Addendum No. 1

RE: Contract ID C203869

Mecklenburg County (I-5768)

I-77 From South Carolina Line To SR-1577 (West Tyvola Road)

STATE	PROJECT NO.	SHEET NO.	TOTAL SHEETS
N.C.	I-5768	8	
WBS NO.	5304.3.1

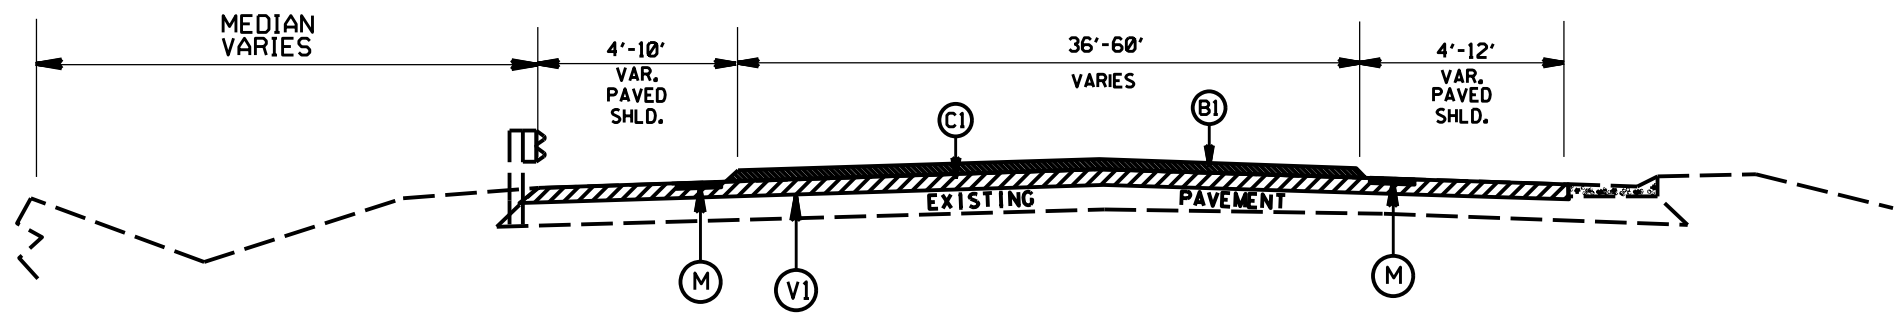
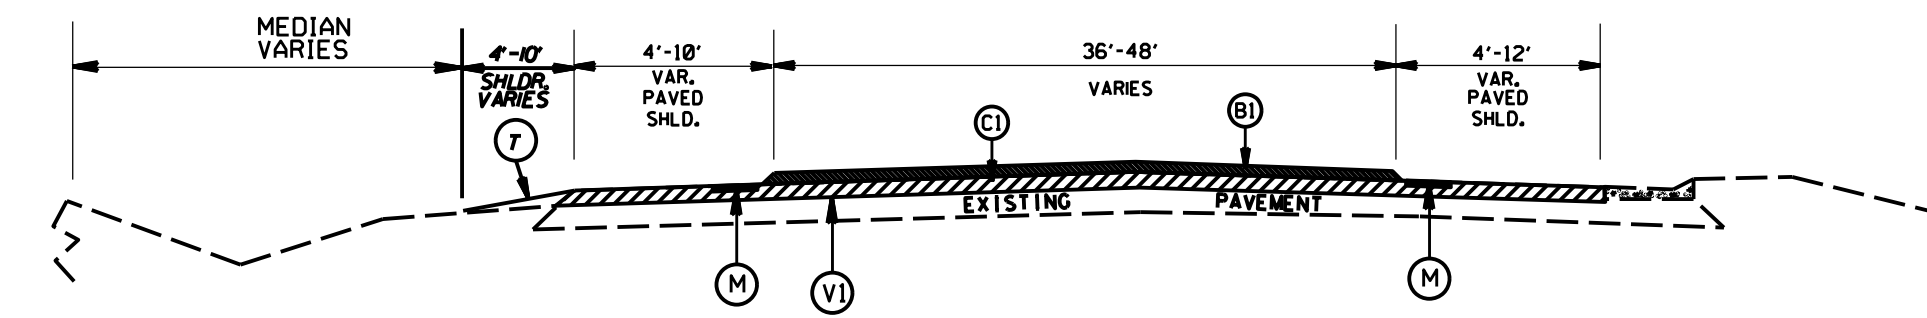
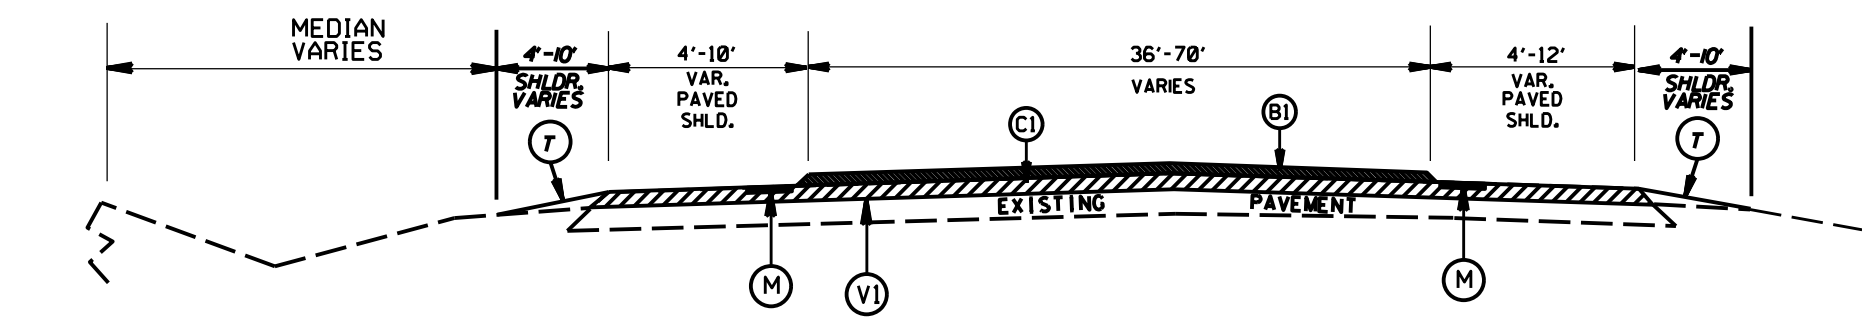
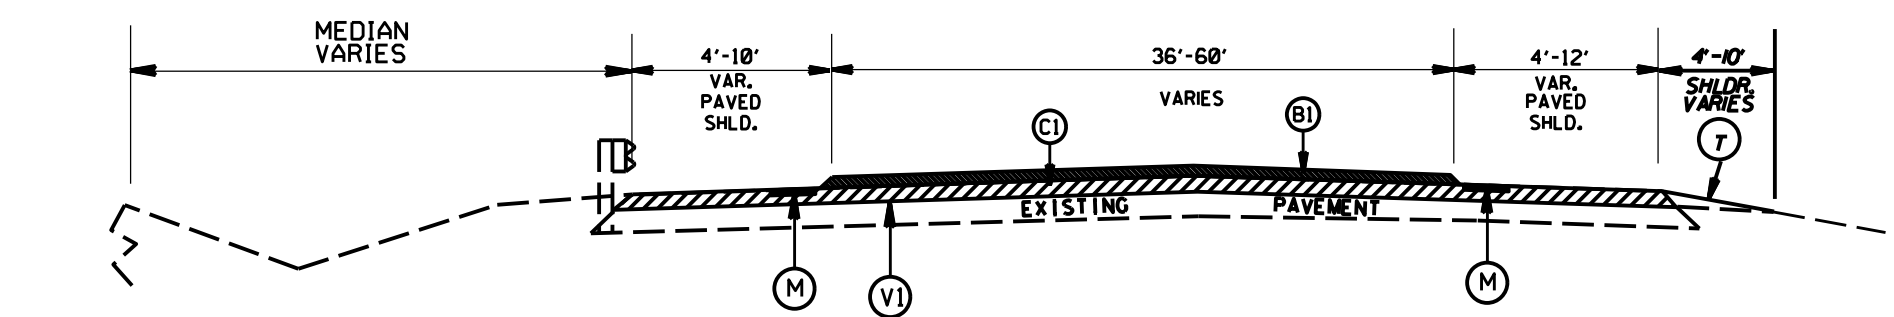
Sheet No.	Revisions
6 thru 25	Revised "C1" in the Pavement Schedule to remove the words "in each of two layers". C1 shall be placed in one layer.
27	Revised the Summary of Quantities to remove the column for "Application of Ultrathin Hot Mix"
